COUNTY COUNCIL'S RESPONSE TO CONSULTATION ON THE FOLLOWING DEVELOPMENT PROPOSAL

Application No: 20/00293/OUT-2

Proposal: Outline application (Phase 1B) including access (all other matters reserved) for approximately 4,413 sqm B1 office space (47,502 sqft) GIA, approximately 273 residential units (Use Class C3) including ancillary gym, approximately 177 sqm GIA of café space (Use Class A3), with an ancillary, mixed use co-working hub (794 sqm/ 8,550 sqft GIA), multi-storey car park, multi-use games area (MUGA), amenity space, associated infrastructure, parking and marketing boards

Response date: 3rd June 2020

Appendix A – Figure 12 from DAS – Regulation Plan

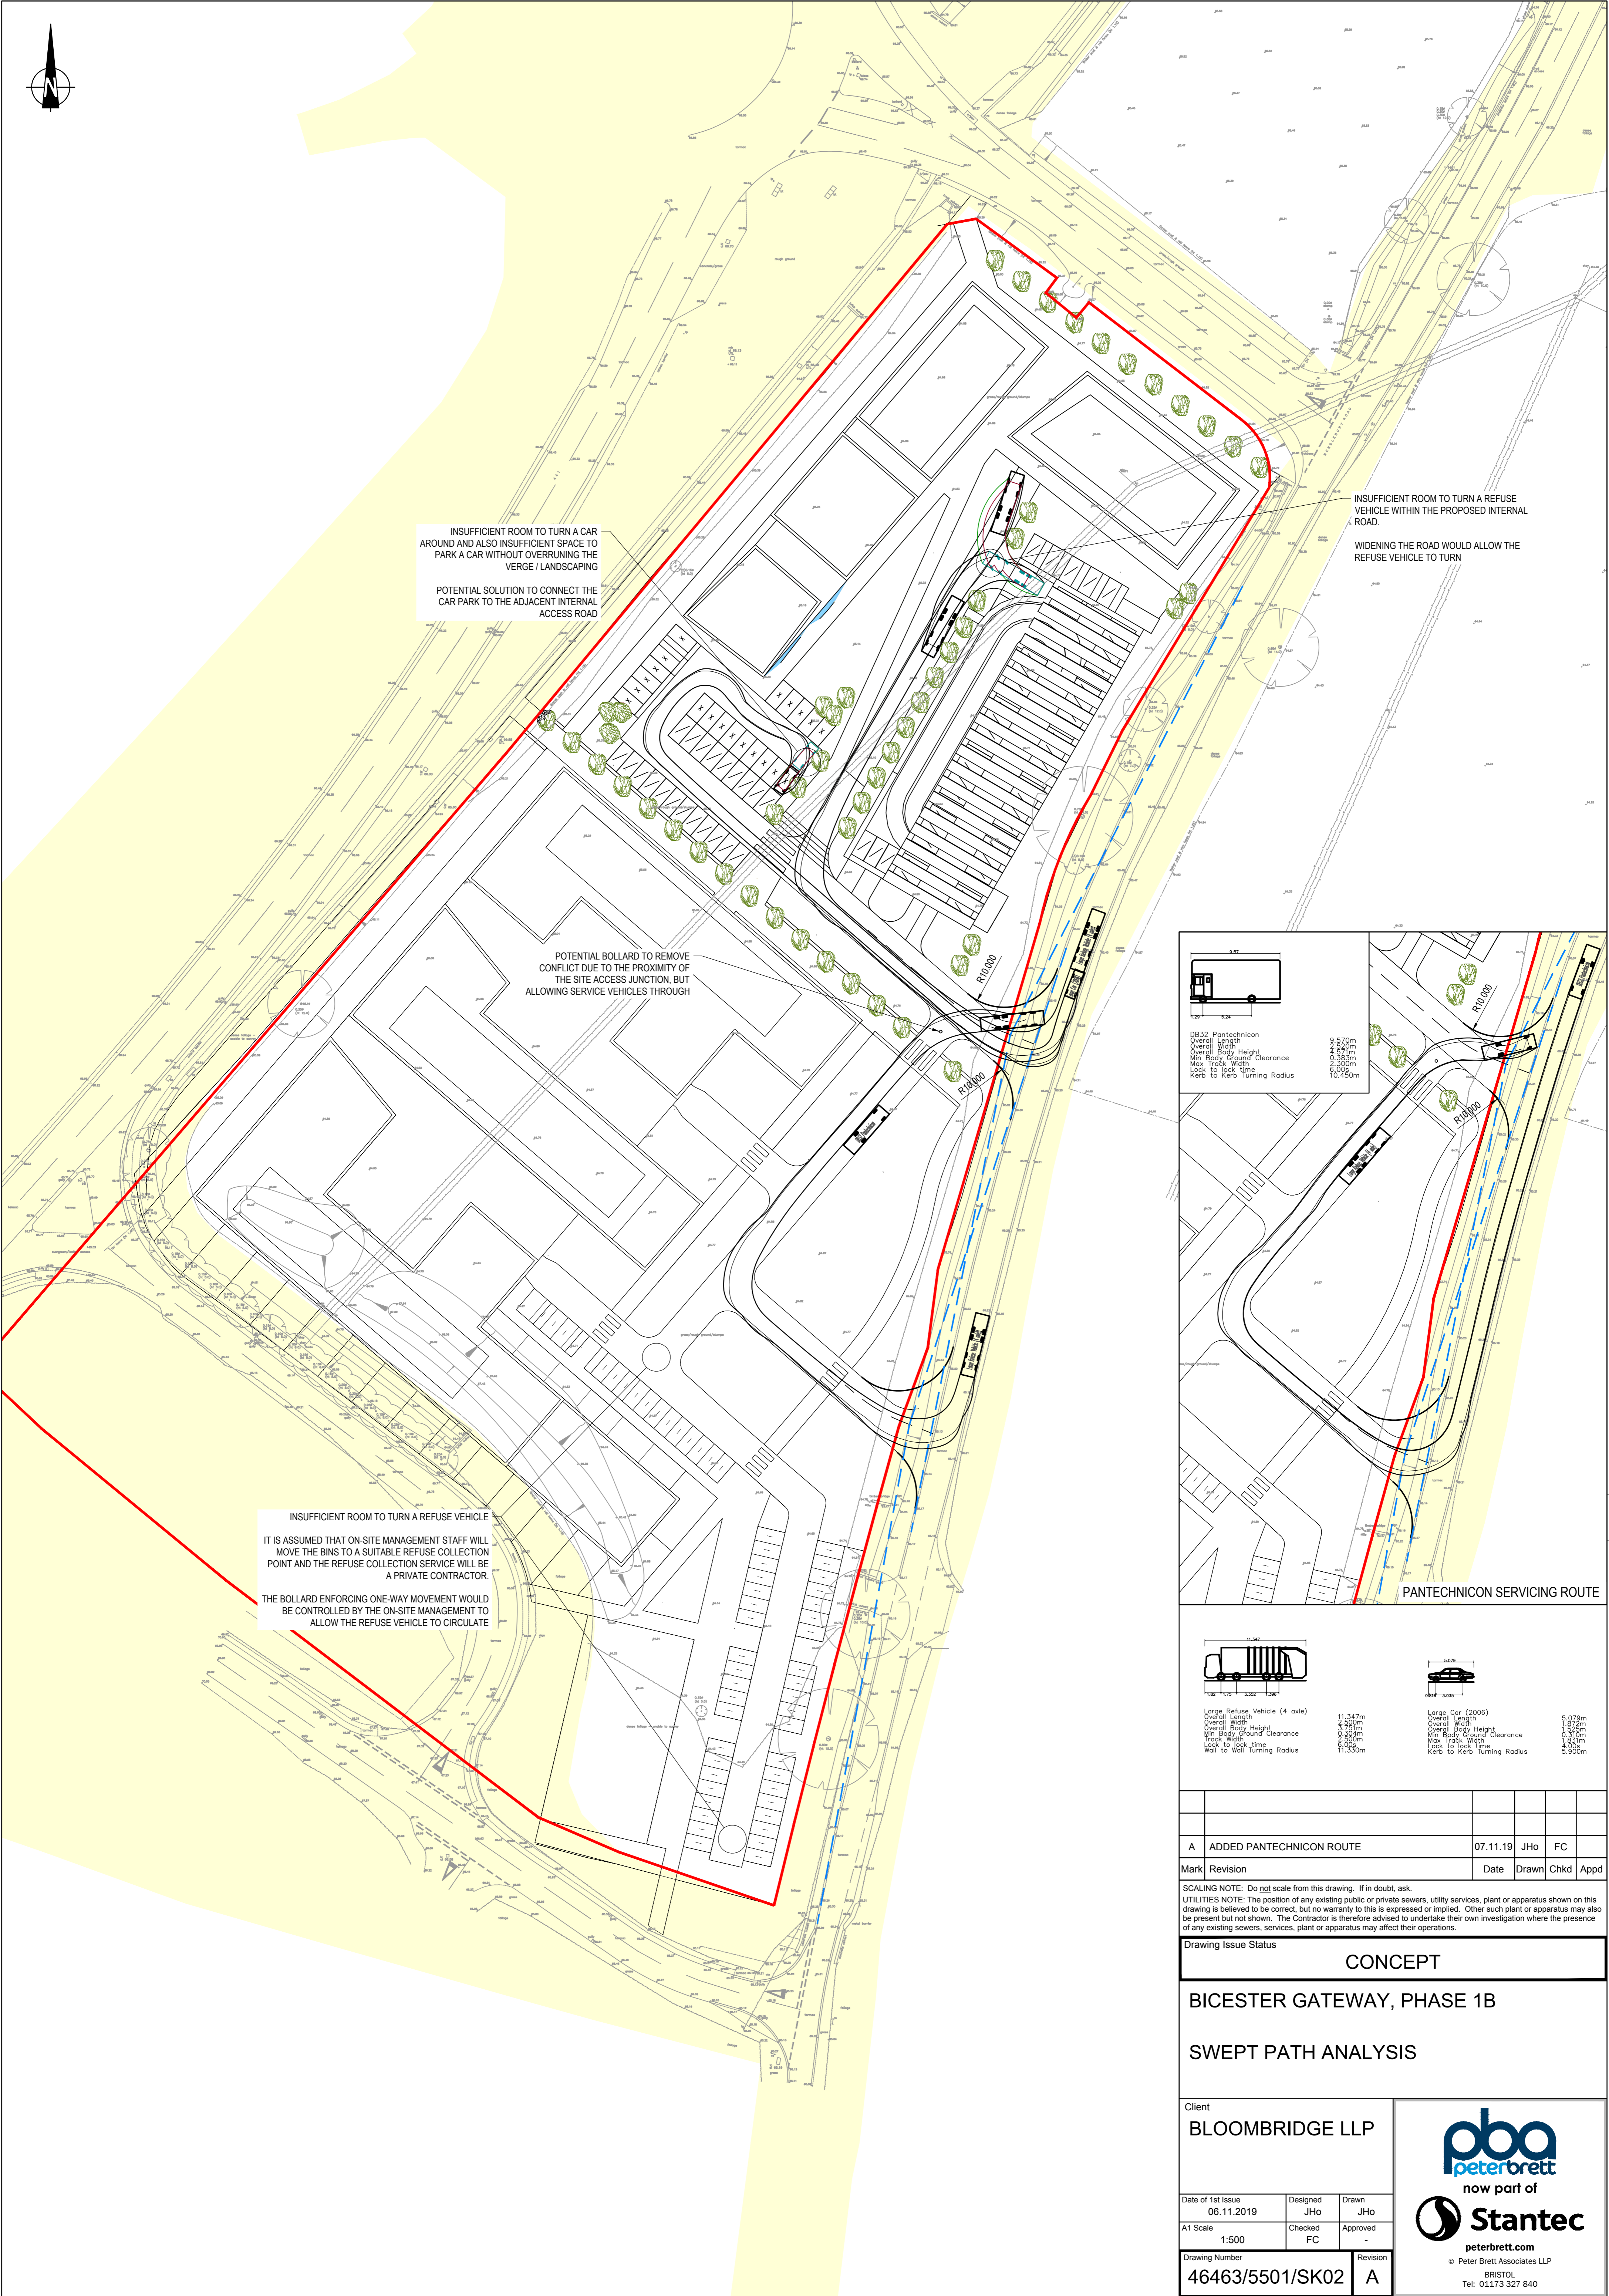
The submitted indicative masterplan shows development within the area previously agreed would be preserved in situ as part of the earlier outline application (16/02586/OUT). These proposed impacts would disturb the significant archaeological deposits in this area and as such would not be an acceptable scheme. The archaeological protection measures submitted for the previous application have not been updated to set out how this area could be preserved, and no such measures have been proposed or submitted with this application.

Appendix B – Tracking Drawing

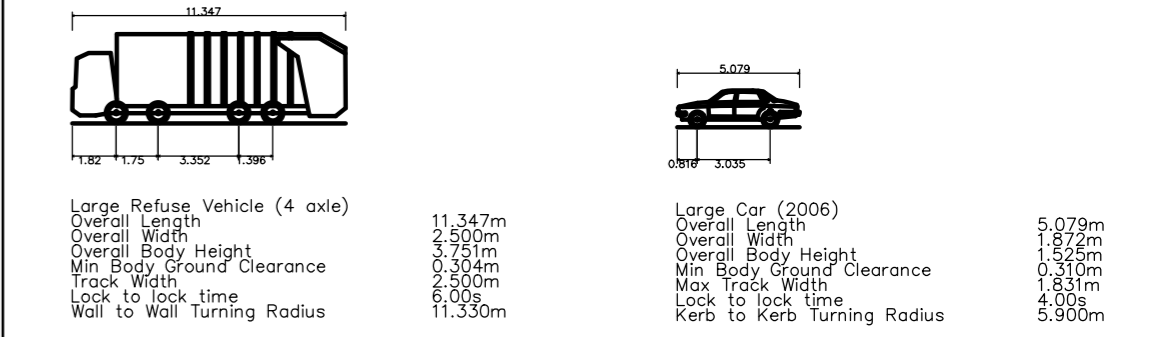
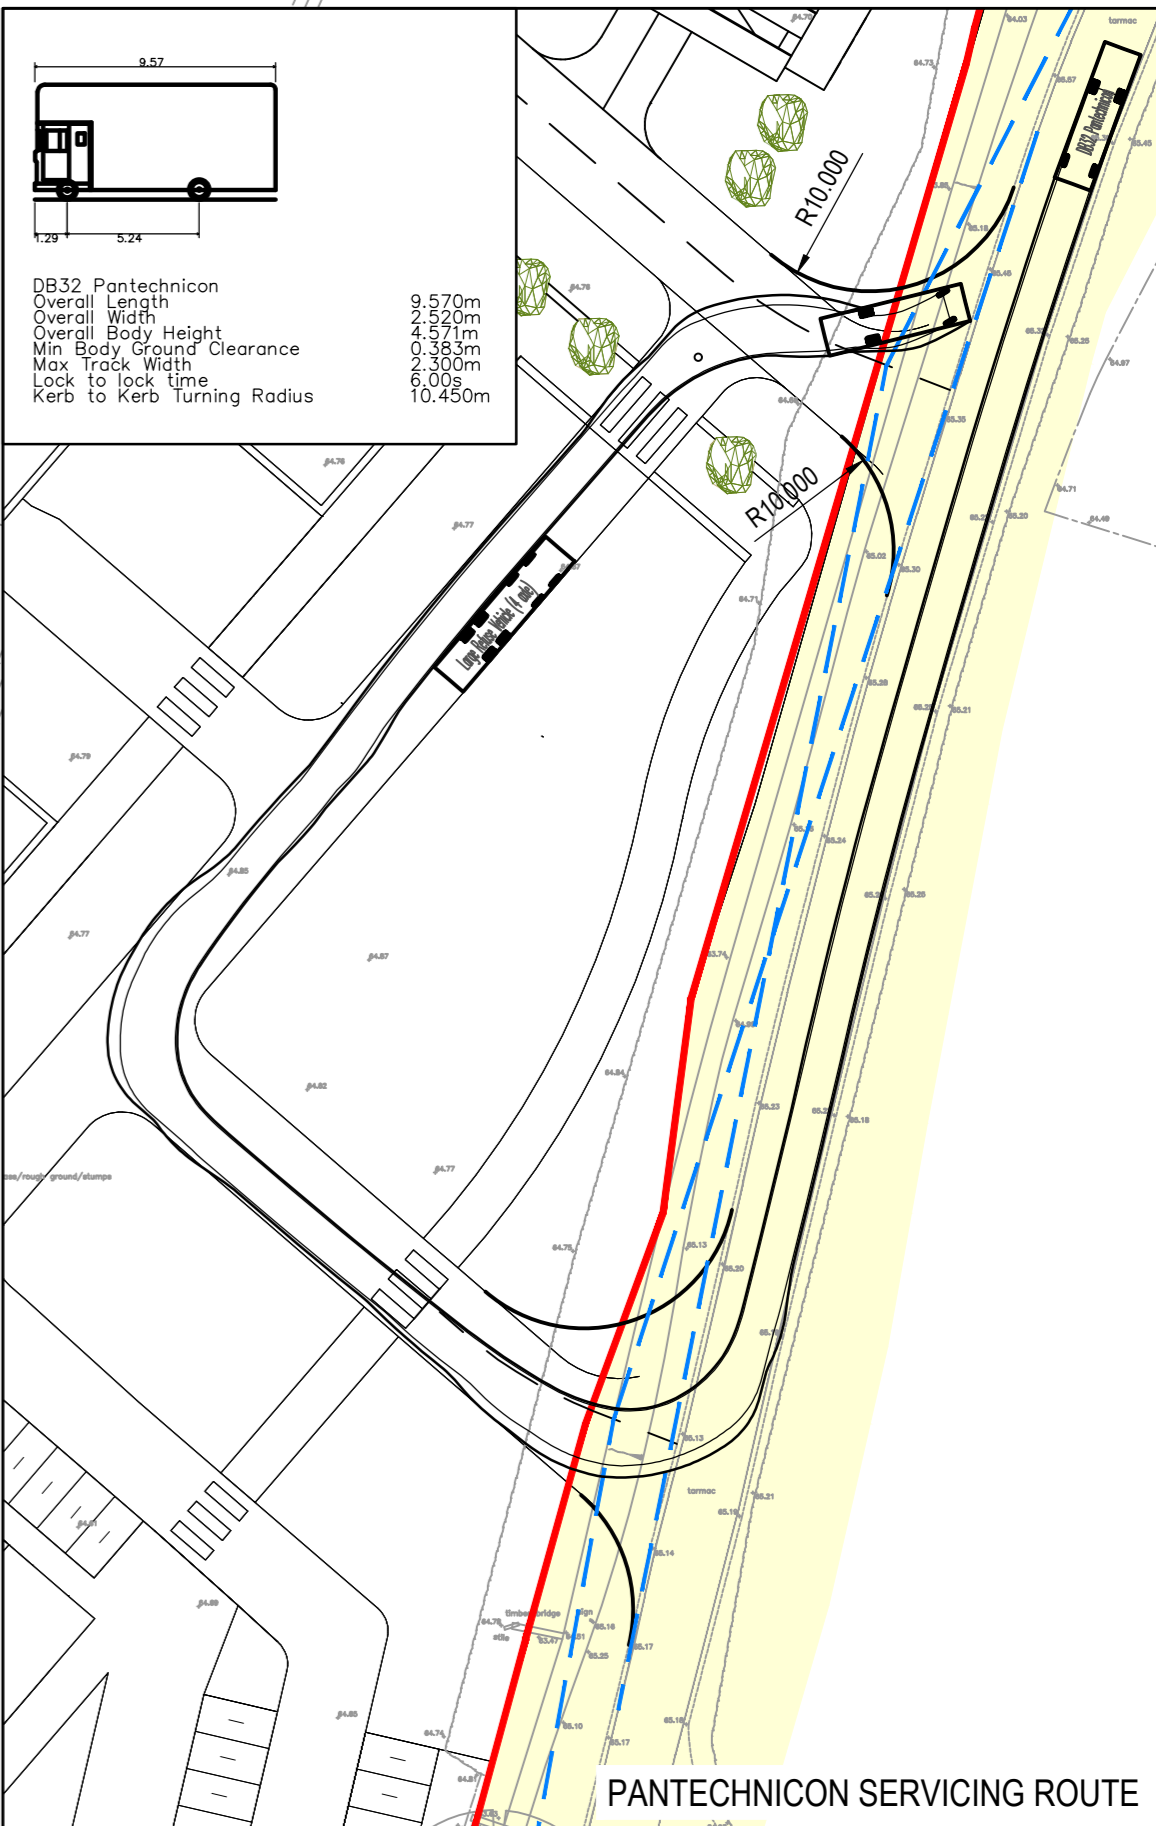
Vehicle tracking showing a large refuse vehicle and a pantechicon has been provided showing that these vehicles can enter and exit the site. However, they do illustrate that Wendlebury Road is too narrow for large vehicles to pass while turning and there may therefore be a need for minor localised widening at the accesses to prevent verges being overrun. OCC has requested a condition requiring full details of the access junctions and we will expect this to be accommodated within the design.
